From: Laura Gibbons [REDACTED]
Sent: 01 February 2022 15:19
To: Planning.Responses [REDACTED]
Cc: Simon Davis [REDACTED]
Subject: RE: Planning Consultation on: Y/185/21/DOC

Engineers Comments Regarding Condition 9

Application No: Y/185/21/DOC

Site Address: Land East of Drove Lane Yapton BN18 0EB

CLIENT	BRN SOUTHERN COUNTIES	DWG. TITLE	DETAILED SOFT LANDSCAPE PROPOSALS FOR PLOTS & HED & SOFT FOR POS
SITE	WATTON		
PURPOSE OF ISSUE	PLANNING		
DWG BY	EM2	CHECKED	JBA
AUTH'D	JBA	SCALE	1:250@A1
DATE	JULY 2020	DWG NO.	JBA19291-03
REV.	1

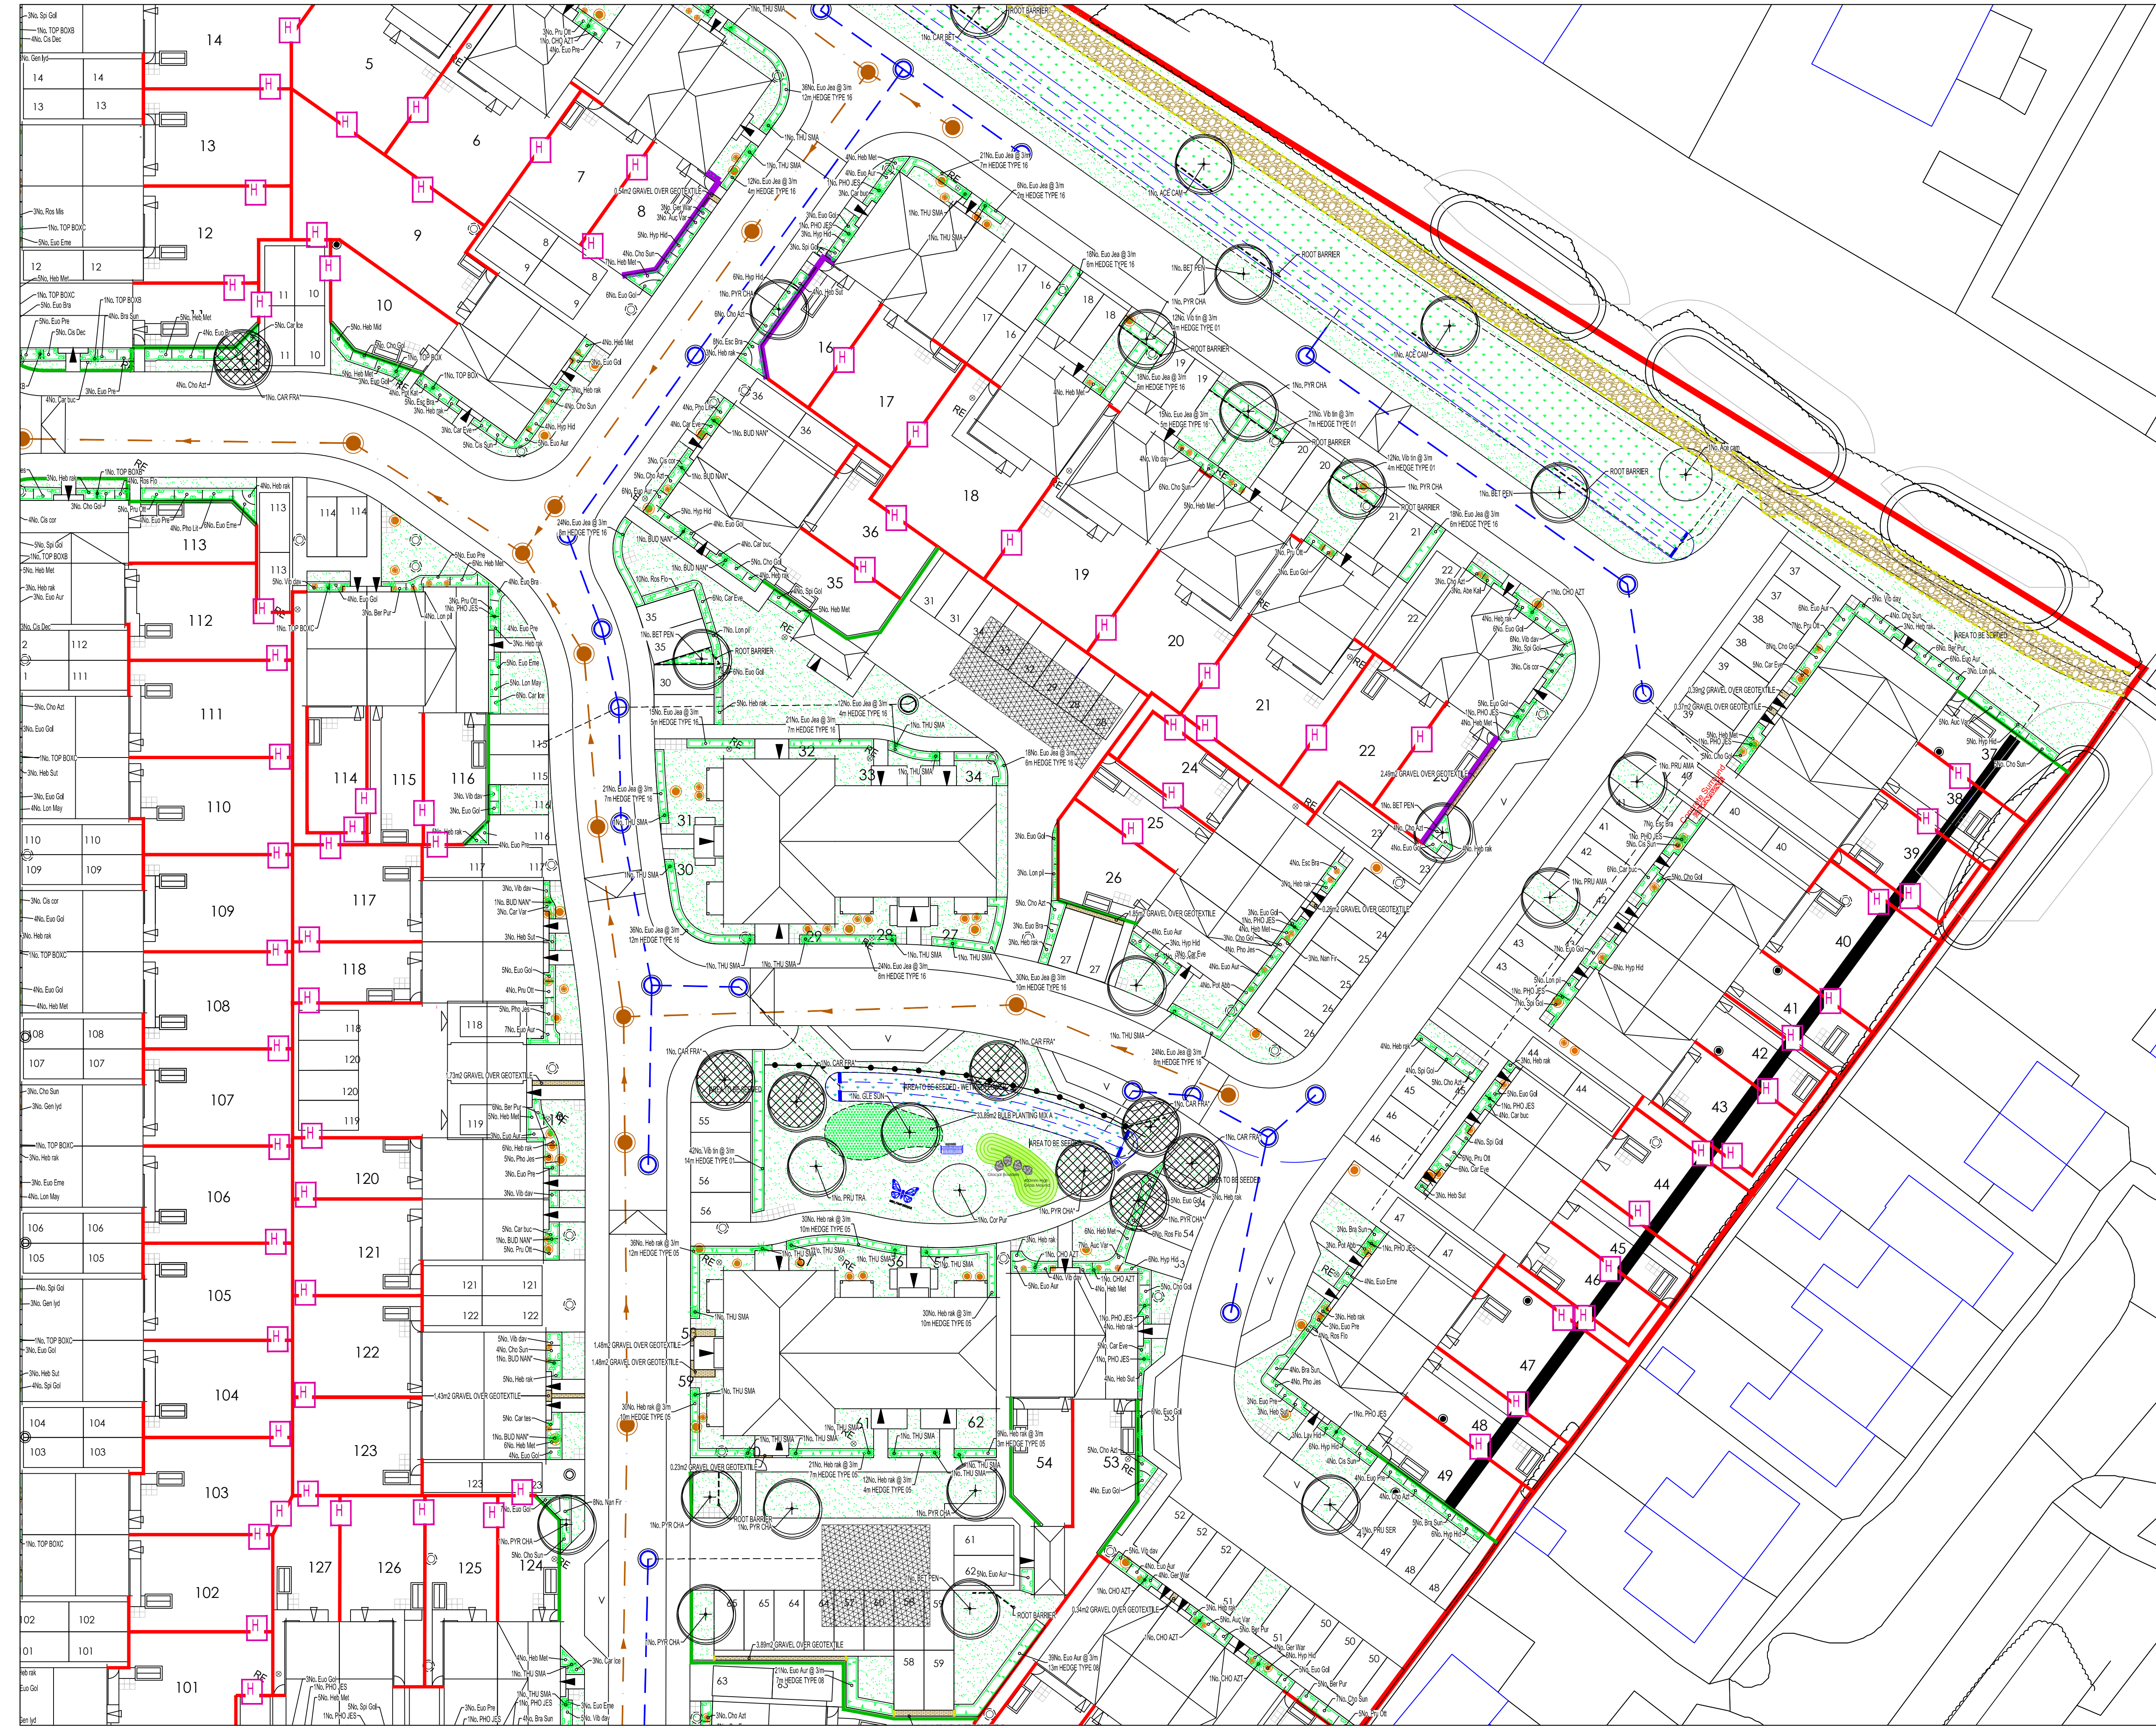
There is significant conflict between soft landscaping proposals and drainage proposals. A significant number of trees are proposed in very close proximity to lined surface water drainage features. Root potential areas should not overlap with SuDS features. We note that some root barriers are proposed, however we do not generally support these. Furthermore, the extent of the barriers proposed would not adequately protect the drainage features.

Please can plans showing root potential areas of trees be provided, with drainage features shown. Once this is provided the tree officer should also be consulted.
